CITY OF ALBUQUERQUE

June 18, 2015

**Re: AIS Retail
12th St & Indian School/Menaul
Grading and Drainage Plan
Engineer's Stamp dated: NONE (H13D106)**

TYPICAL CROSS SECTION FOR FIRST FLUSH PONDING IN PARKING LOT MEDIANS

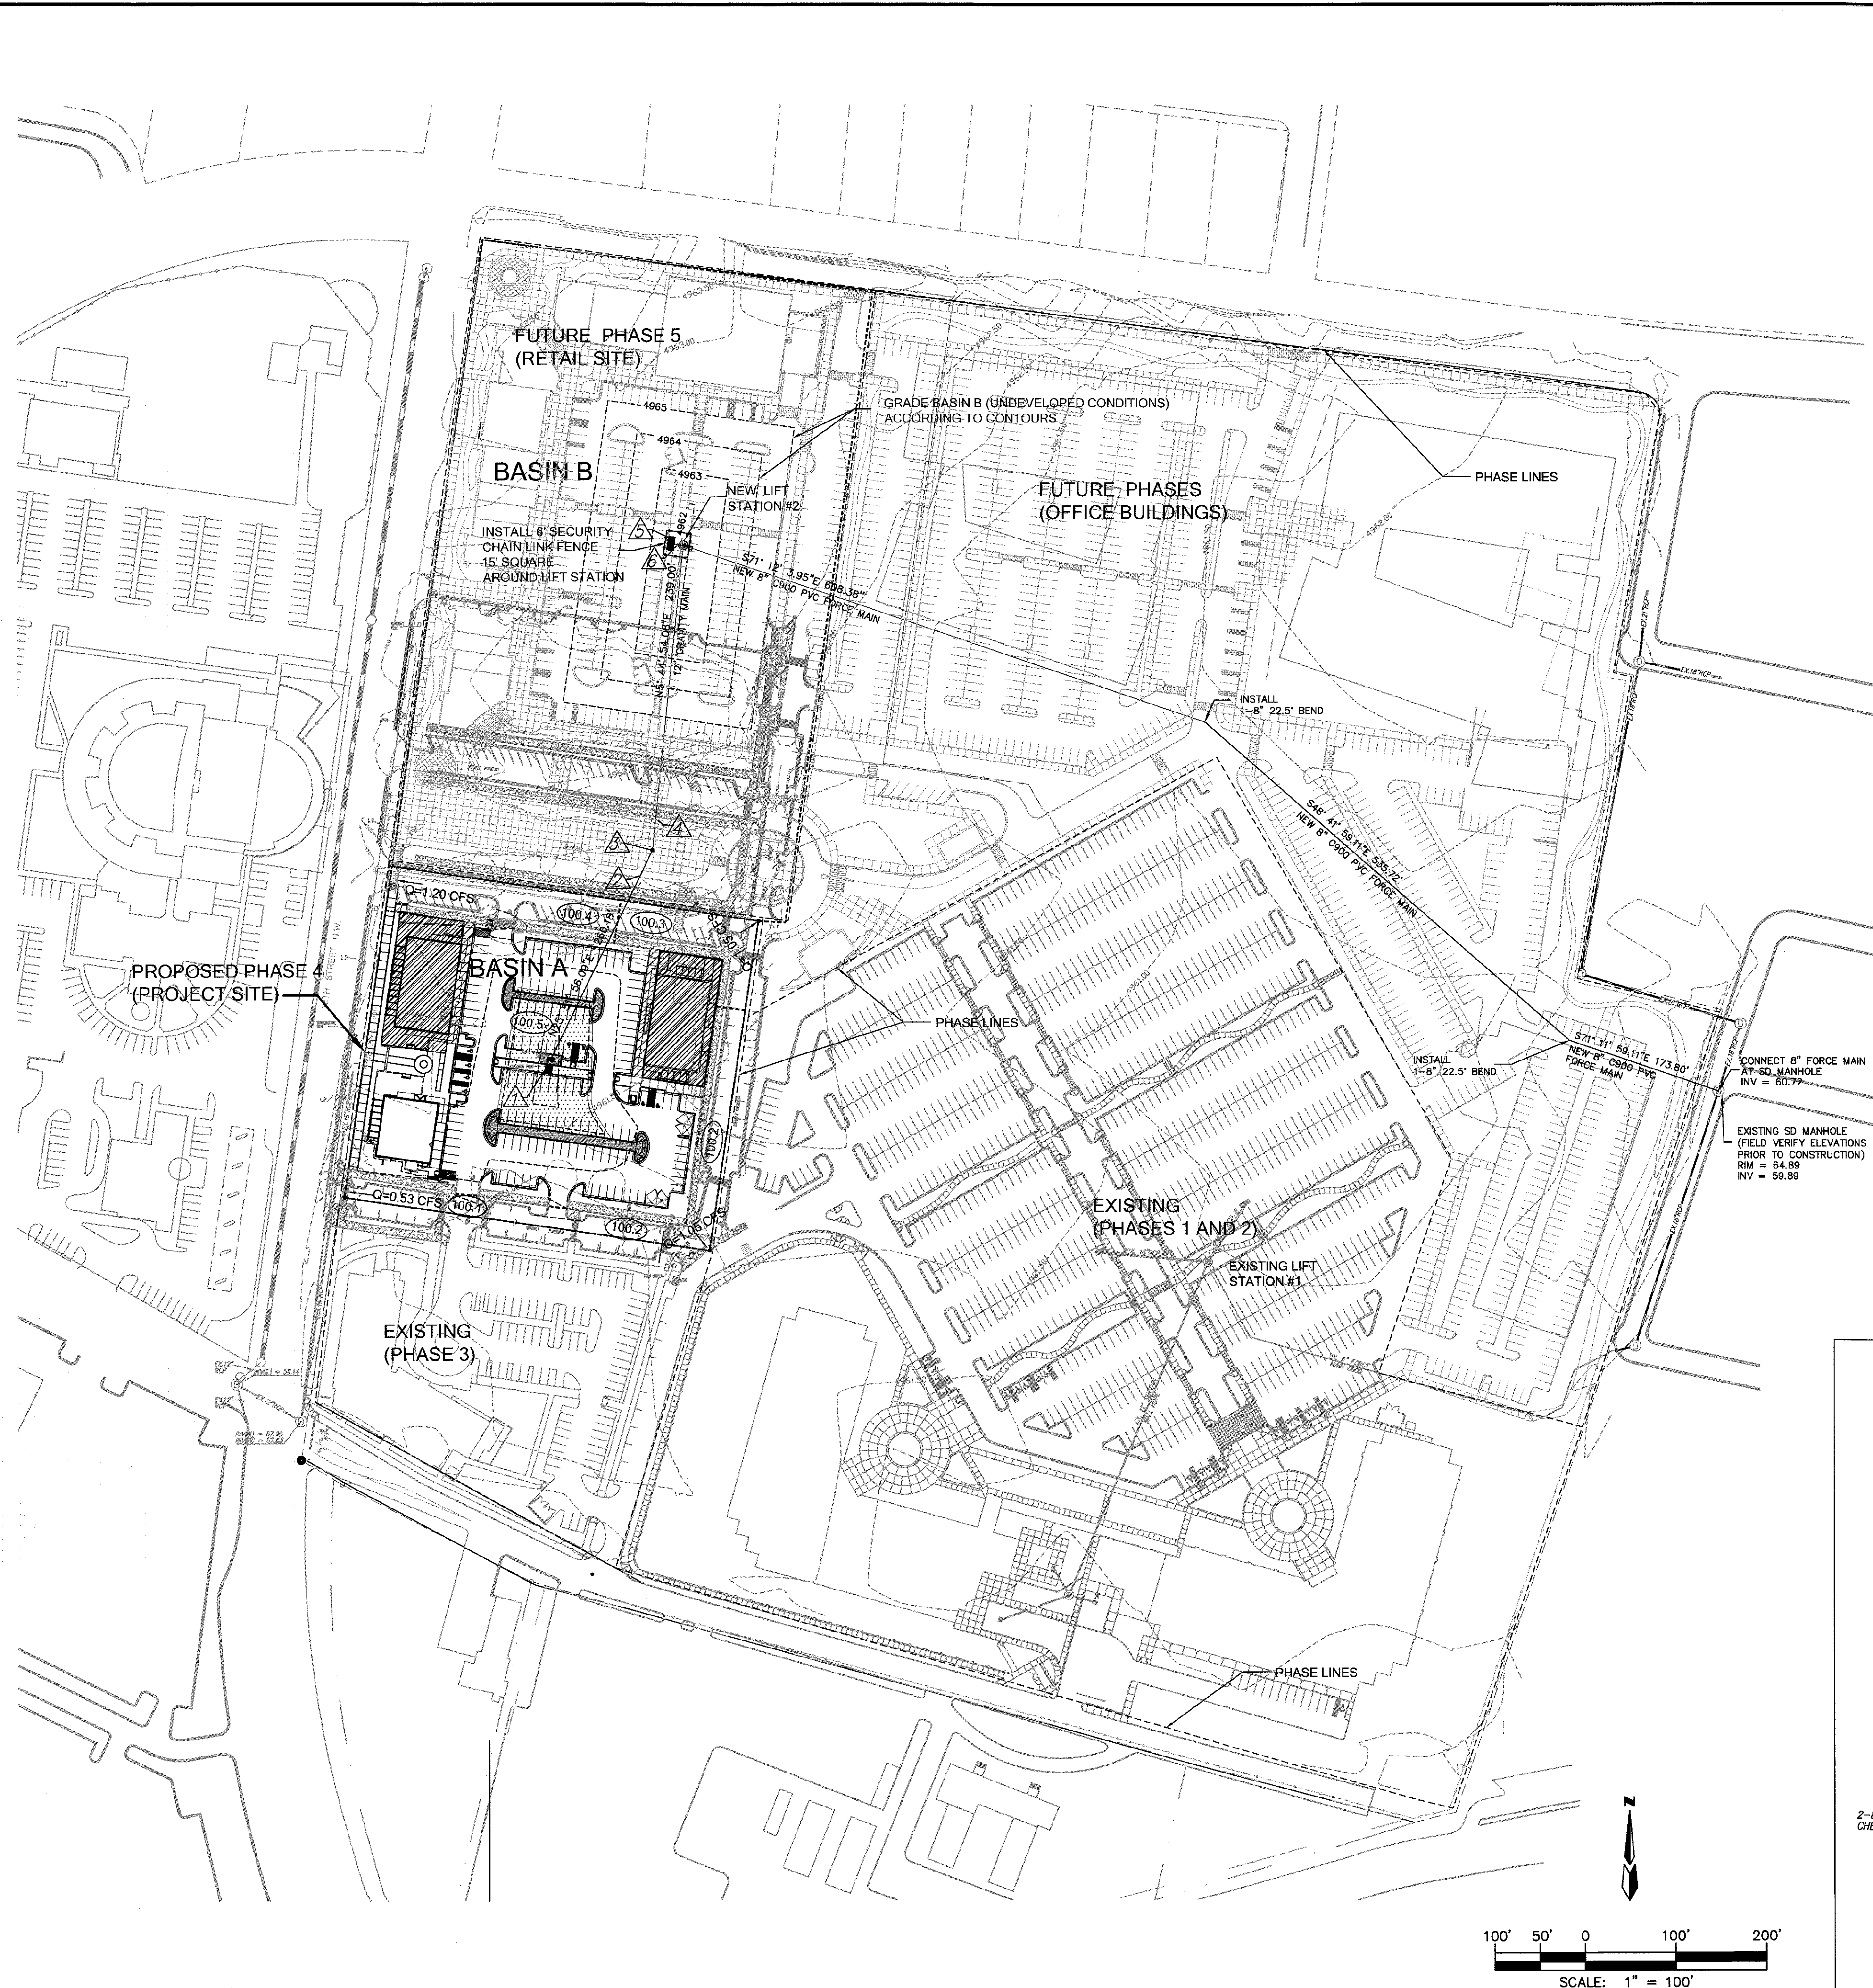
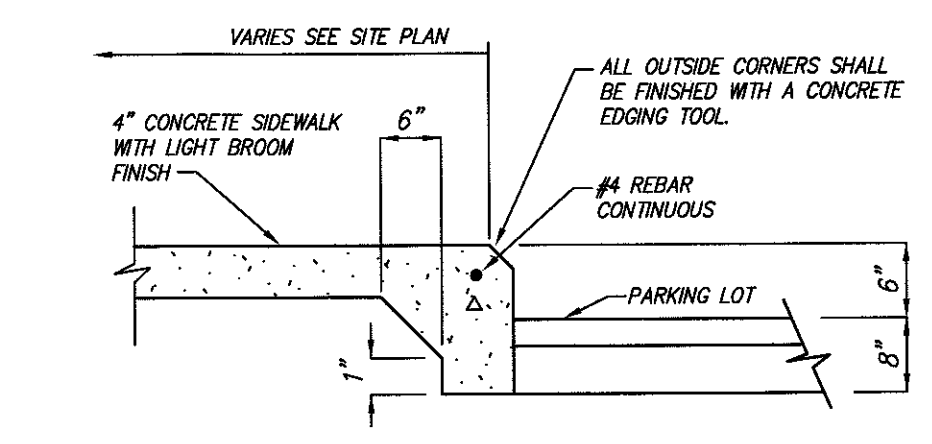
- The plan does not state how the first flush is being accomplished. The first .34" times the impervious area must flow through a pond or some type of landscaping before entering the public storm sewer system.
- Provide how this site will be phased.
- An ESC plan must be submitted and approved before approval of the building permit.
- The plans provided are not signed or dated.
